Item No. **Report of the Head of Planning, Transportation and Regeneration**

Address 96 BOURNE AVENUE HAYES

Development: Conversion of roof space to habitable use to include, increase in ridge height, addition of pitched roof over flat roof element, a rear dormer and 1 front rooflight

LBH Ref Nos: **76034/APP/2020/4095**

Dwg no: 0105-PR-12	Revision. B	Date: 18.09.2020
Scale: 1:50@a3p	Drawn by:	Checked by:

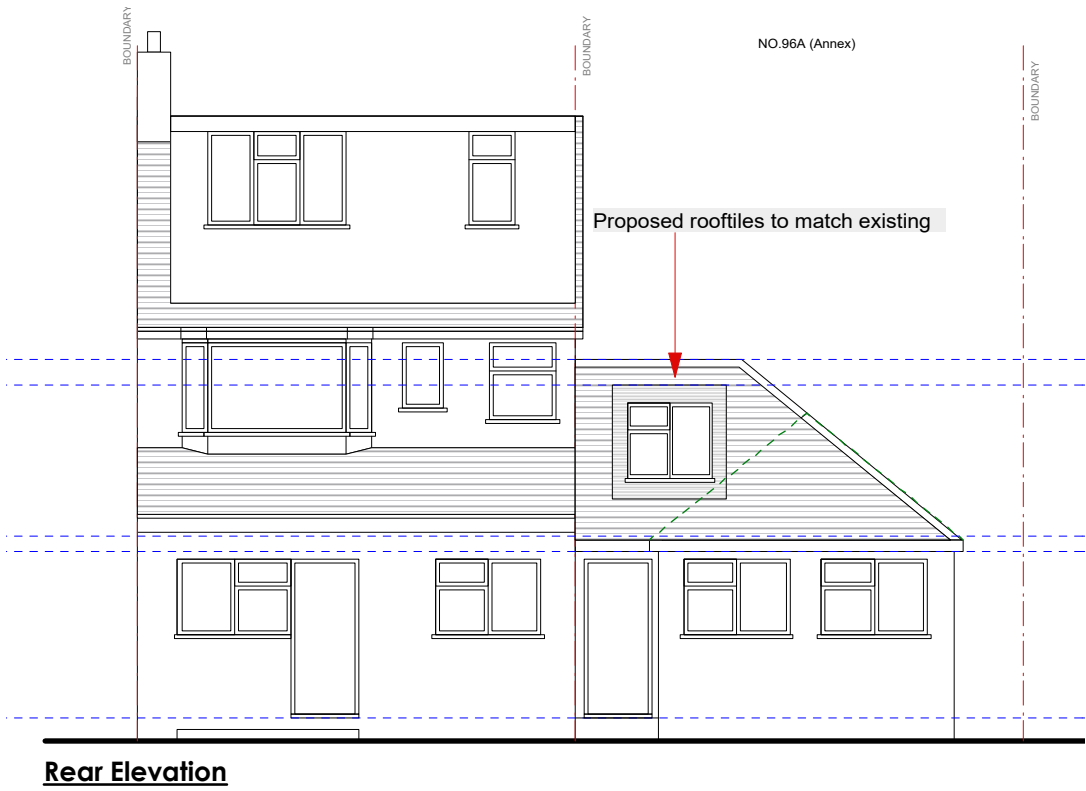
Whilst the proposed rear dormer would be set-ins from both sides of the roofslope, it cannot be said to appear secondary to the size of the roof face within which it will be set. The proposed roof alteration will not appear subservient to the host property, as it will cover most part of the roofscape and create the appearance of an effective flat roofed second storey.

A raised ridge to the roof, together with hip to gable conversions to one side and a rear dormer, would be constructed, significantly increasing the massing of the roof and changing its profile in views from the front, side and rear. A new rooflight to the front would be introduced

Dwg no: 0105-PR-20	Revision: B	Date: 18.09.2020
Scale: 1:100@a3p	Drawn by:	Checked by: R.SH.

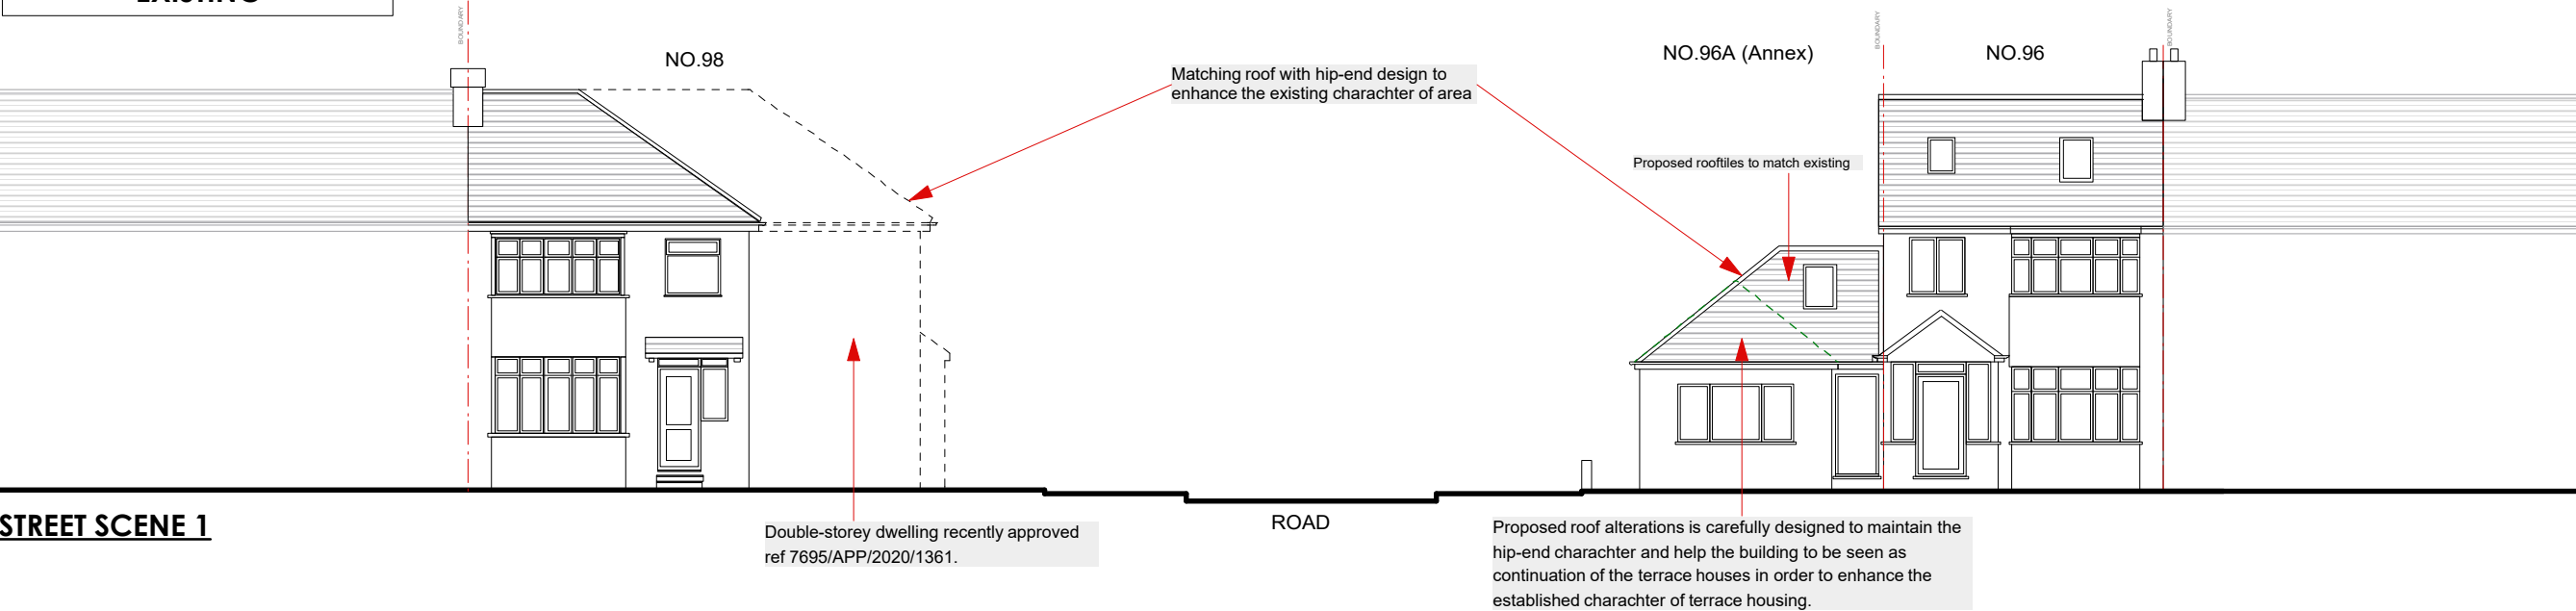
The proposal would involve roof extension to include hip to gable end on one side of the roof within the front elevation attached to the side elevation of the adjacent property and a rear dormer with a single rooflight within the front roofslope. It would be clearly visible and appearing obtrusive within the street scene.

The increased scale and substantially greater massing of the proposed roof would be a disproportionate and over-dominant addition to the application building, which would be readily visible from Bourne Avenue and Clevedon Gardens. Furthermore, the design of the enlarged roof, including its disproportionate height in relation to the rest of the building would also be unsympathetic to the host building.

Whilst the rear dormer would be a modest size addition to the roofscape, its position means it would be very prominent in public views and its design and massing would be out of keeping with the host dwelling.

The raised ridge to the roof, together with hip to gable conversion to one side and a rear dormer, would represent a significant change to the appearance of the application dwelling. The design would be considered unsympathetic to the host building and the greatly increased massing at first floor/roof level would make this a disproportionate and over-dominant addition that would be readily visible from the public realm. The height and massing of the proposed extensions would make it a visually prominent and incongruous addition to the host building. It would significantly reduce the sense of spaciousness, in this case at first floor level, to be found at this corner location, which is a characteristic feature of the area.

Dwg no: 0105-PR-21	Revision. B	Date: 18.09.2020
Scale: 1:150@a3p 1:500@a3p	Drawn by:	Checked by: R.SH.

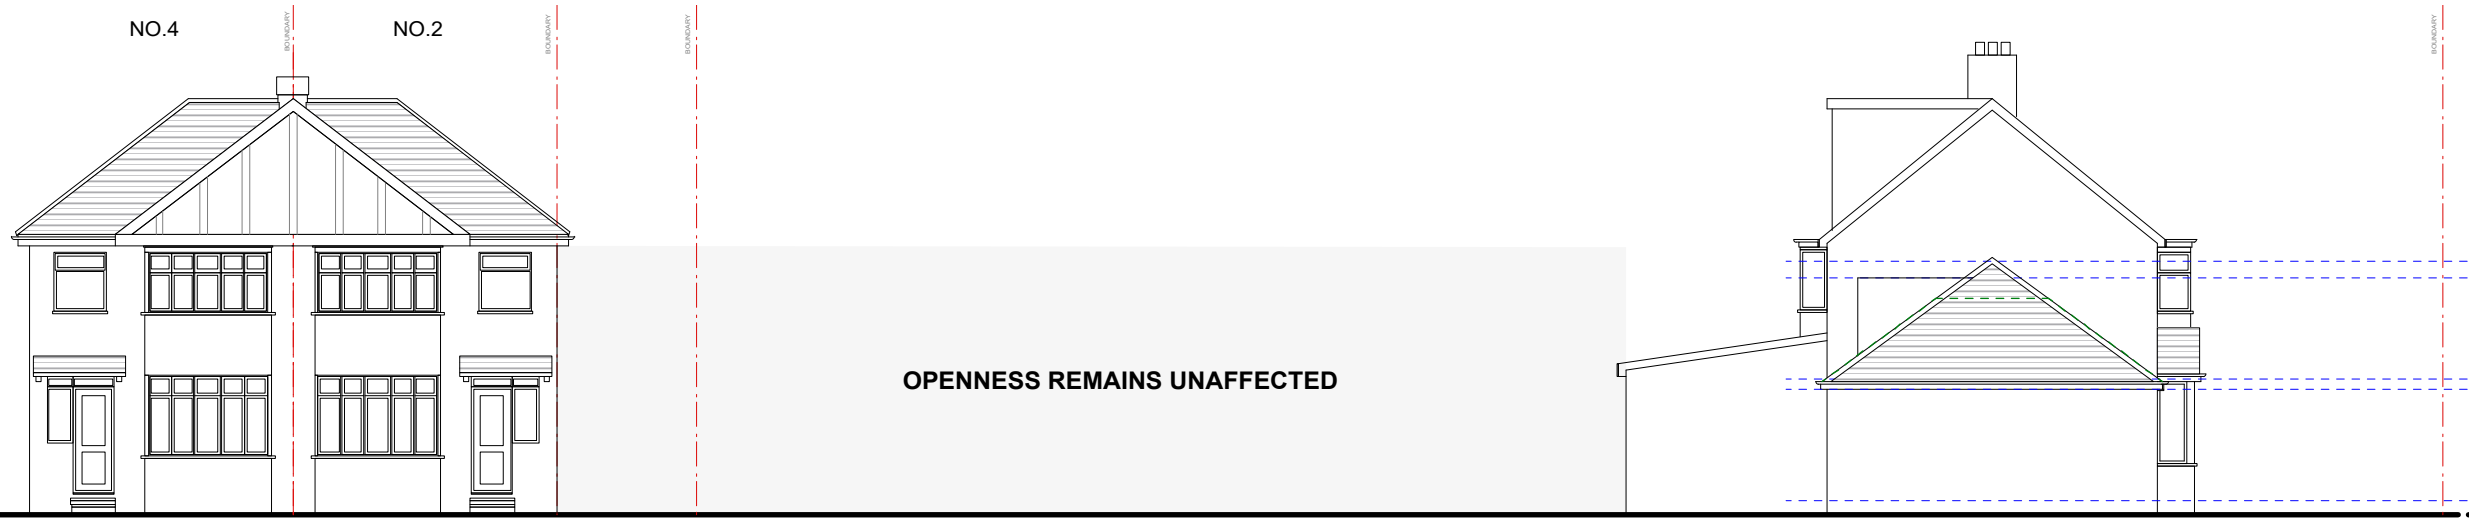
The proposed development would entail substantial alterations to the application dwelling that would be readily visible from the public realm, such that an existing detached dwelling would become a semi-detached dwelling by virtue of this alteration
